WATER AND SEWER PLAN
PRELIMINARY
STANFORD COURT
 Town of Addison, Dallas County, Texas

PROJECT NO.
CDC004
 SHEET NO.
3

PROJECT NO. CDC004
 SHEET NO. 3

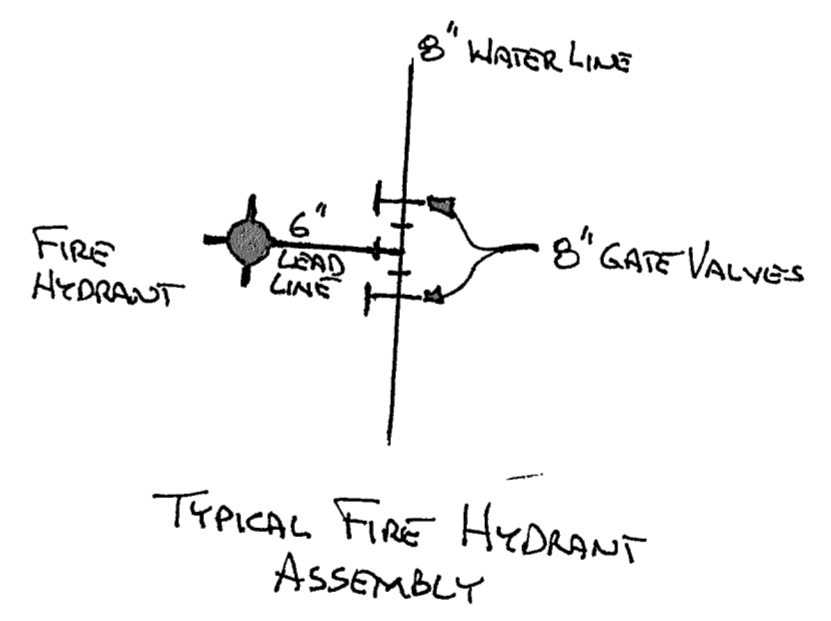
Fire Sprinkler service per bldg. or unit?
Domestic service per bldg. or unit?
Common Irrigation Service?

IF Fire/bldg - Double-check detector Assembly in vault
Domestic WA svc must have appropriate backflow preventers

Show WA and SAN Pro files

IRRIGATION MASTERS (LOCATIONS)
